White Hill Wind Farm

## Annex 1.4: Scoping Response from Carlow County Council

**10<sup>th</sup> June 2021**

**RE: Pre-Application Scoping Request: Proposed Wind Farm Development in  
County Carlow and County Kilkenny.**

**Annex 1 –  
Maps and Drawings**

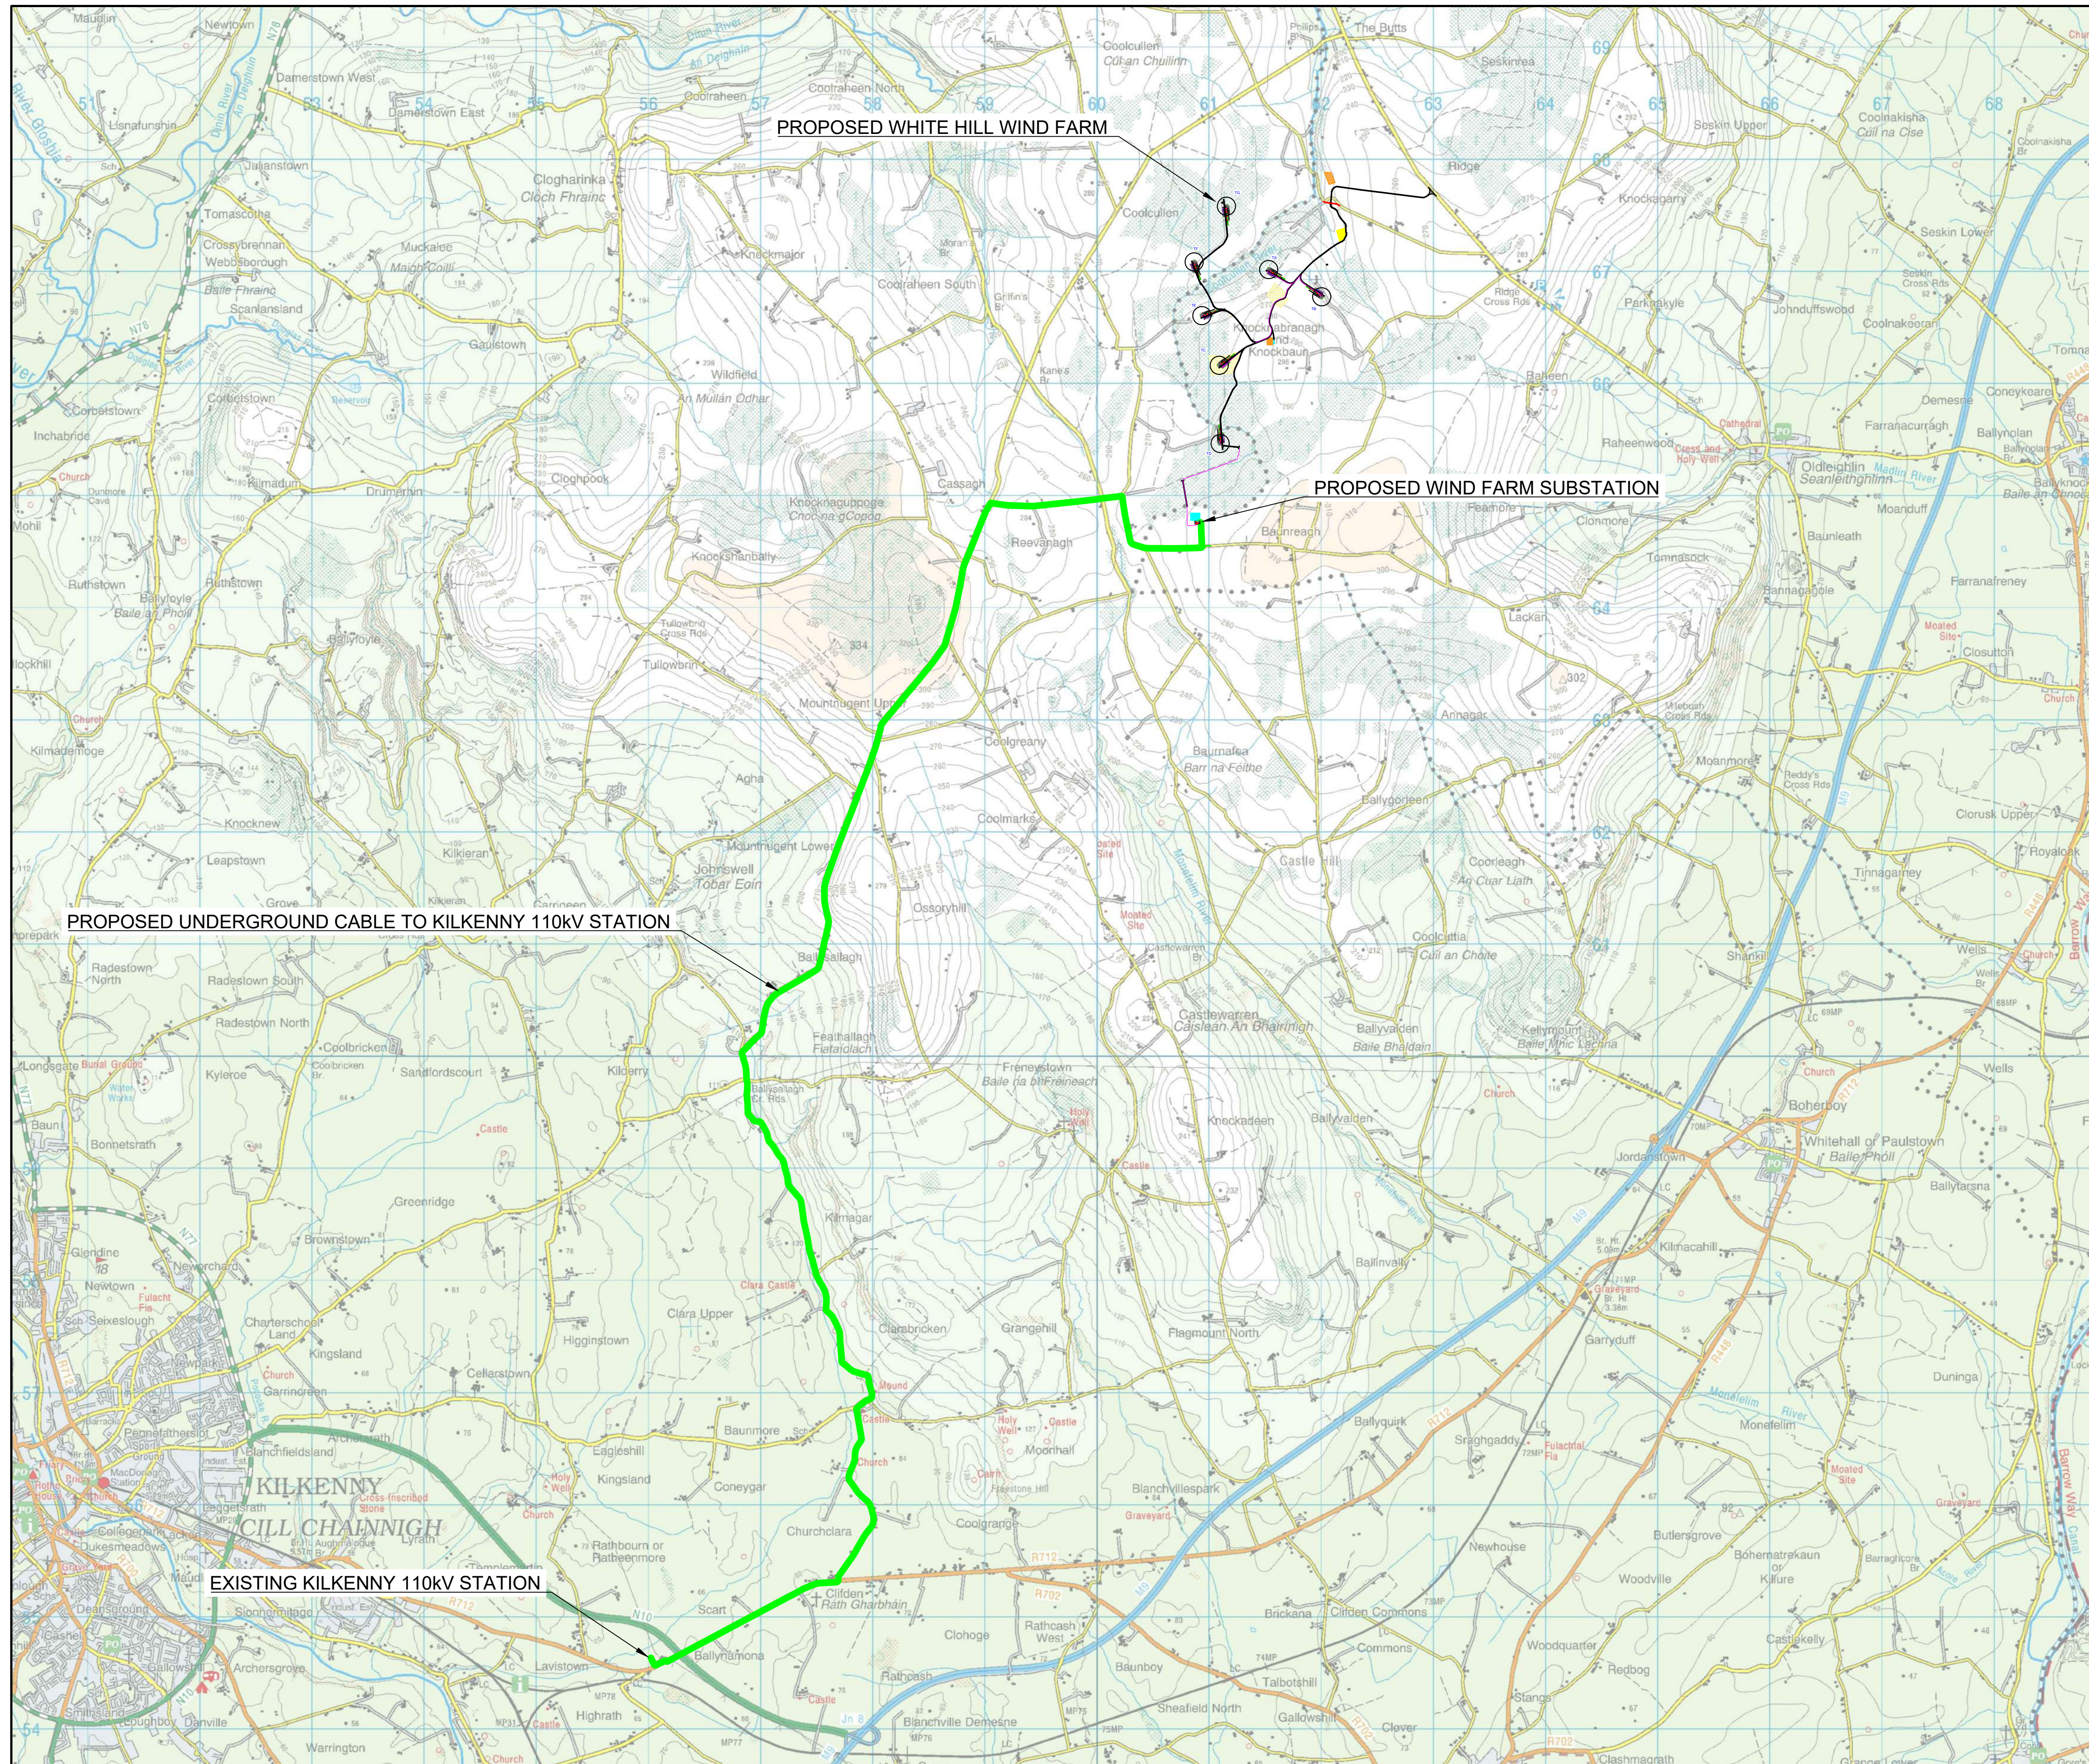
- Figures 1 and 2 included with the submitted scoping report identifies indicative turbine locations close to the public road to the north of the site, the L30371. The L7123 and L3937 are designated scenic routes (no. 6 – Ridge Cross, no.7 road to Butts). The proposed development has the potential to negatively impact on the scenic value of this route.
